**From:** [Harmon Rita T.](#)  
**To:** ["eevaldez@wilsonco.com"](mailto:eevaldez@wilsonco.com)  
**Subject:** G18D048 Montgomery Complex Drainage Report (Stamp date 5/16/16)  
**Date:** Wednesday, June 08, 2016 4:46:48 PM  
**Attachments:** [landscape-buffer-swale.pdf](#)  
[ESC Permit notification sign 1-5-16.docx](#)  
[Stormwater Quality info sheet.pdf](#)  
[stormwater\\_control\\_ESC\\_Permit.pdf](#)  
[FPD Form Revised April 2014.pdf](#)

Based upon the information provided in your submittal received 5-16-2016, the above referenced report cannot be approved for ESC Permit (Building Permit ) until the following comments are addressed:

PROJECT NO: 1460006901
DESIGNED BY: EEV
DRAWN BY: EEV
CHECKED BY: EEV
DATE: AUG 2016
SHEET TITLE
**FULLY DEVELOPED
SITE PLAN
FIGURE 4**
SHEET NO:
PAGE 9

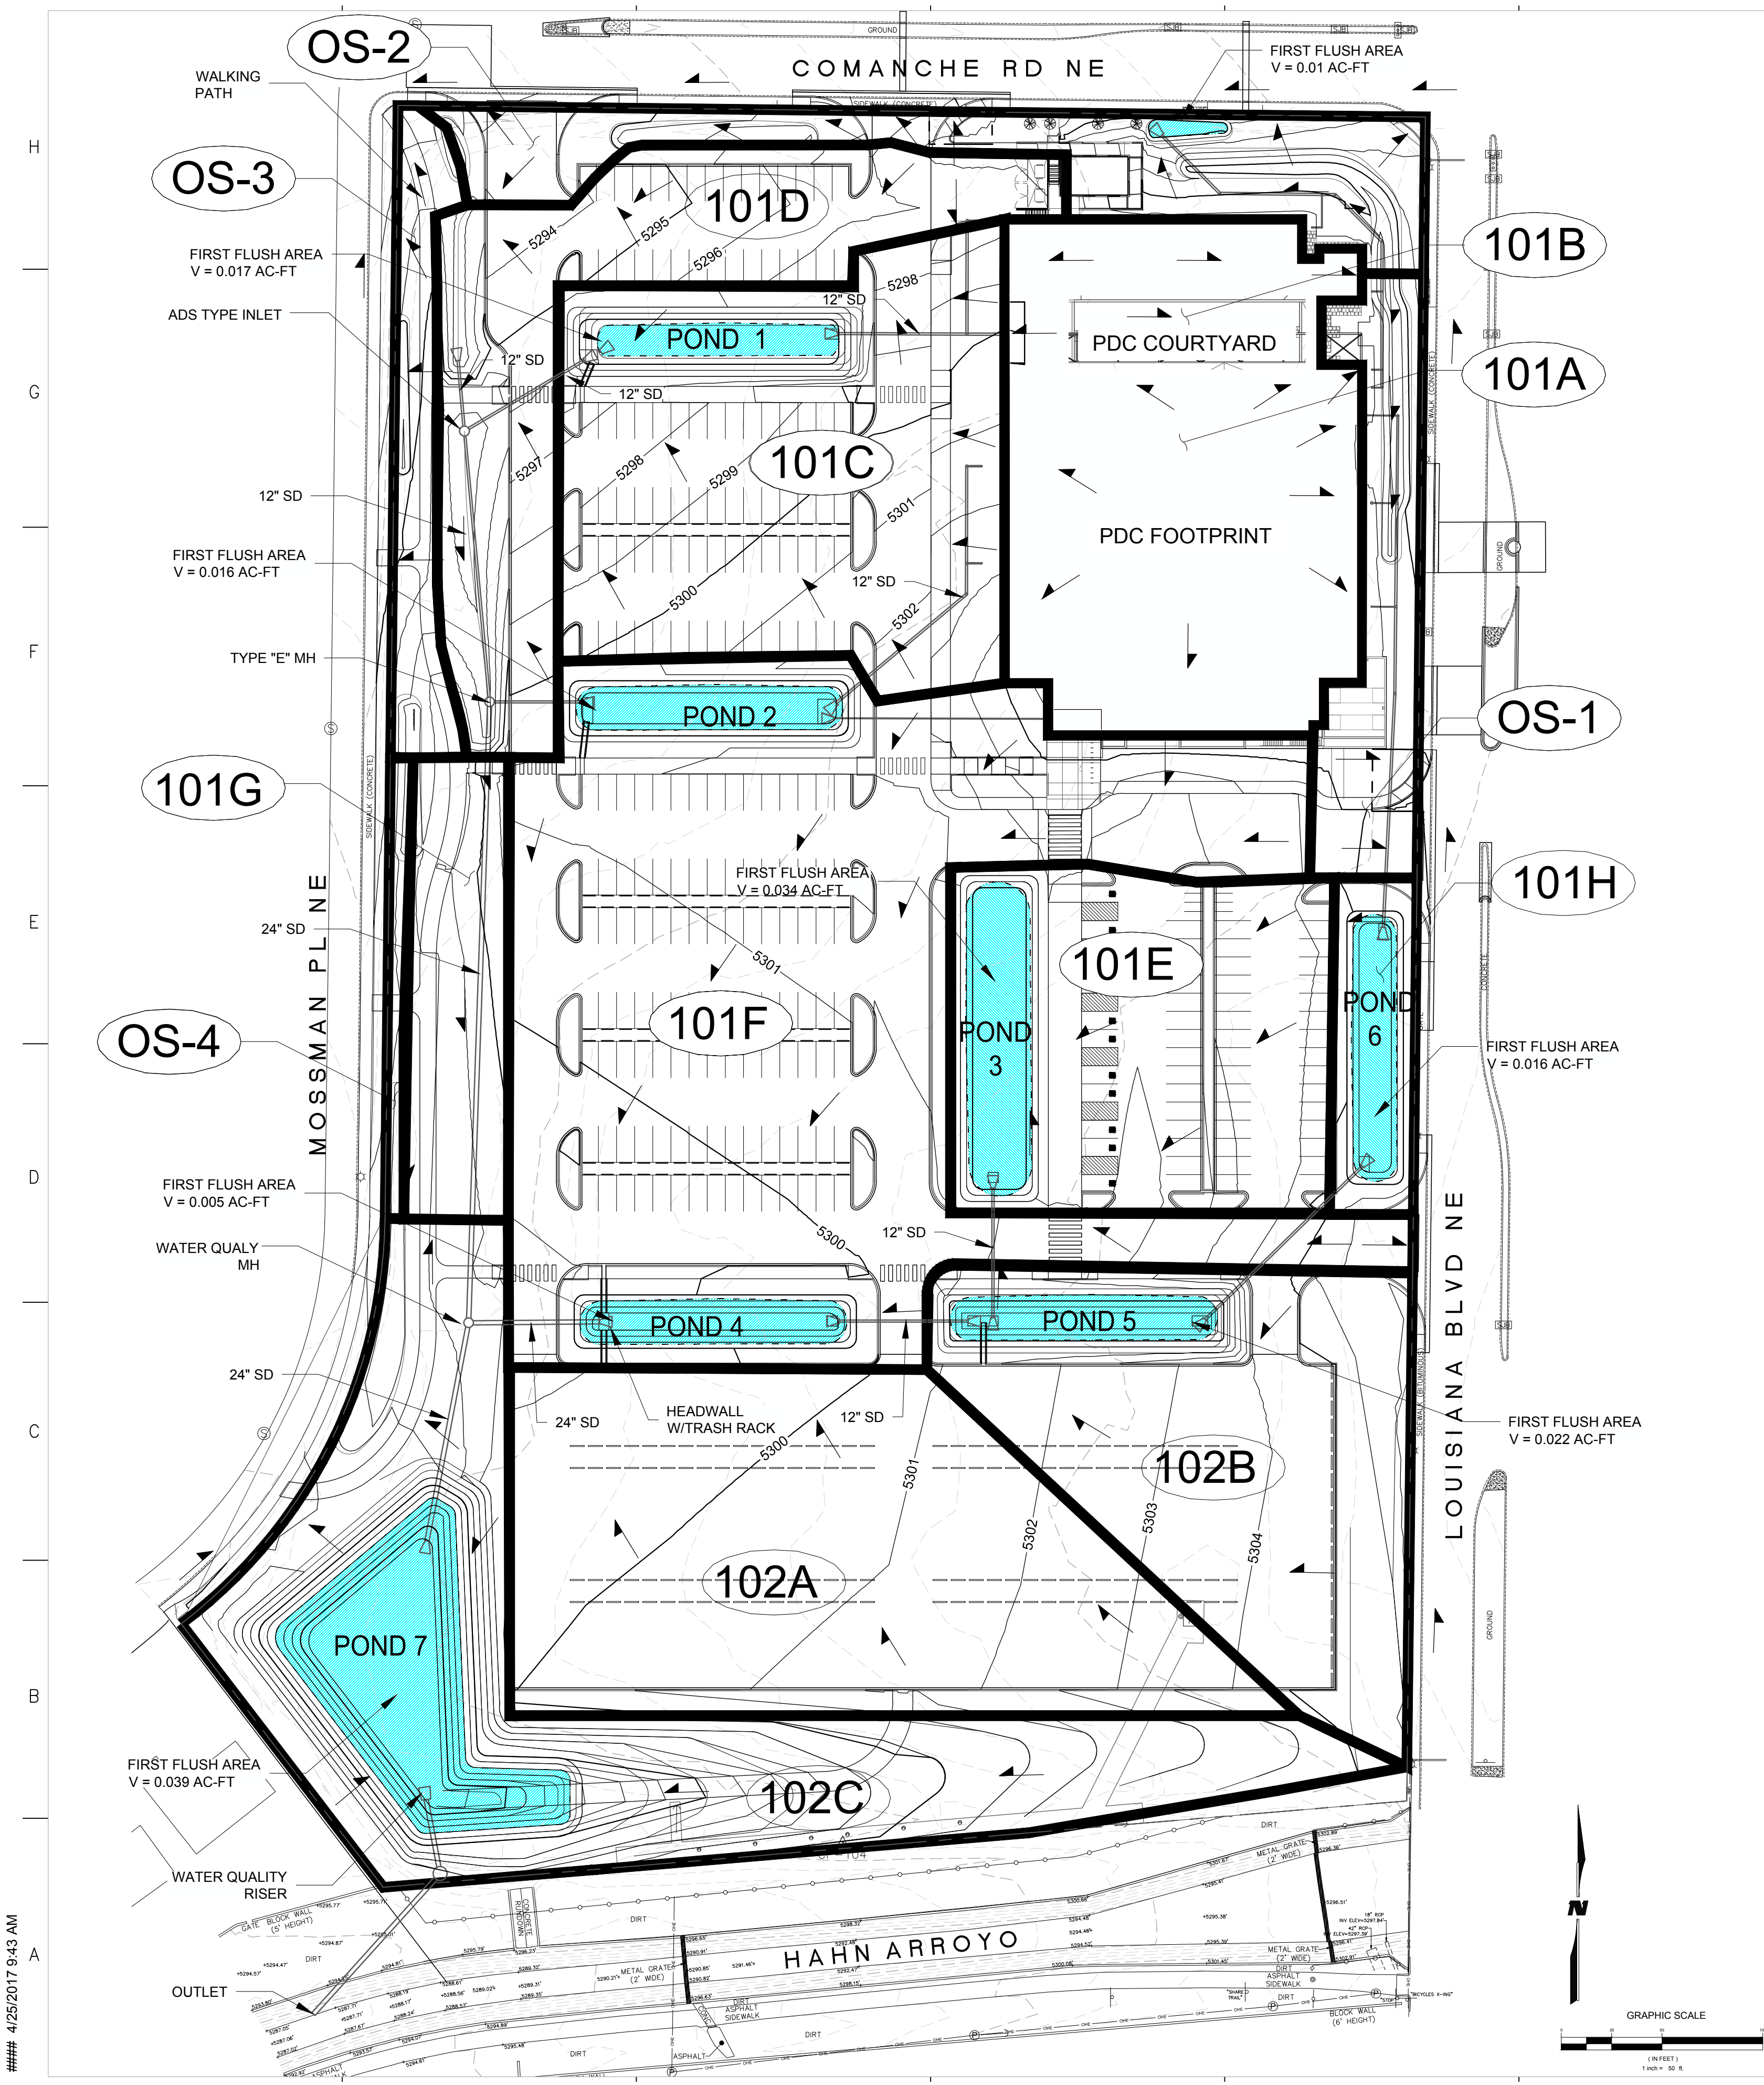
- Show the First Flush pond for the Phase 2 site.
- Revise Figure 4
  - rename as “Fully Developed Site Plan” (or something of that nature)
  - Show conceptual building and parking areas

- Show All First flush ponds and continue to show the detention areas
- Add a paragraph in the report summarizing the interim drainage plan (the detention pond will discharge into the Phase 1 SD System via a storm drain, and will be used in the future to tie to the underground detention system).

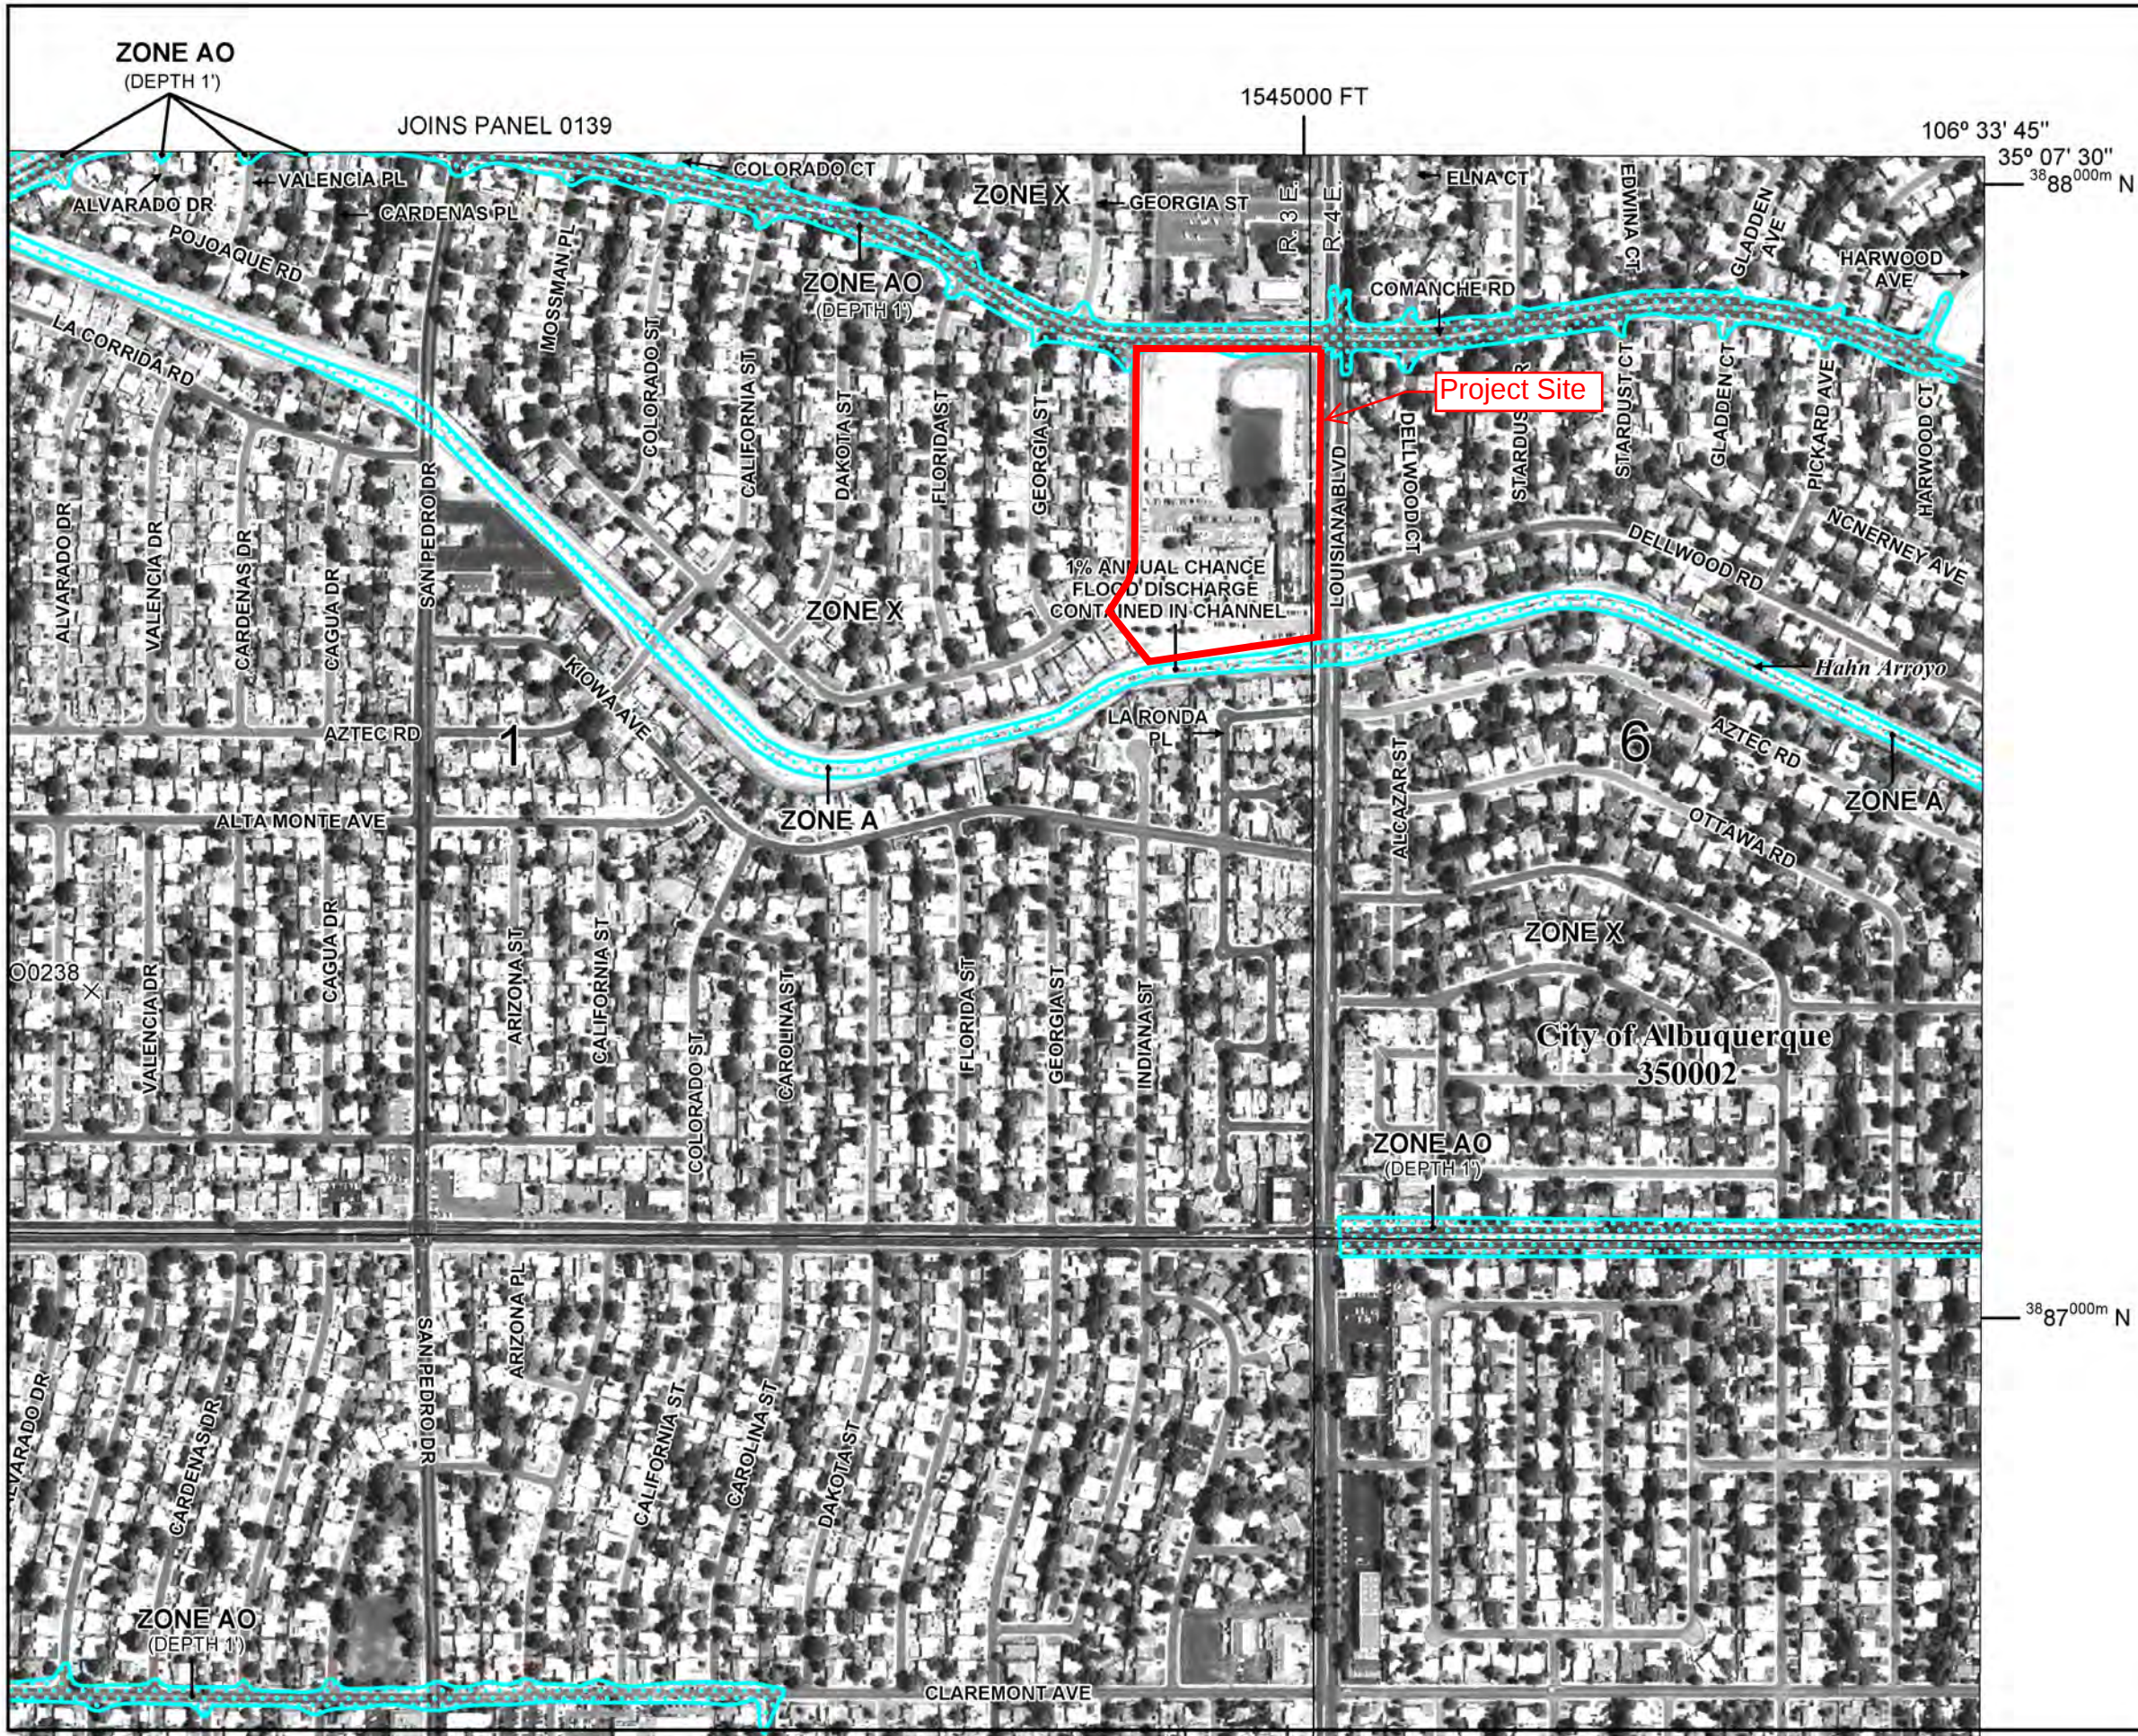
- Storm Drain under parking garage should discharge to a First Flush Pond. Perhaps the Drainage Swale can be widened to accept this flow.
- Revise Figure 5, reflect any rerouting.

- Rename “Basin Map” or something of that nature
  - Revise flow arrows
  - show the future impervious area (Phase 2) . Indicate that it is a conceptual boundary of the 75%D area.
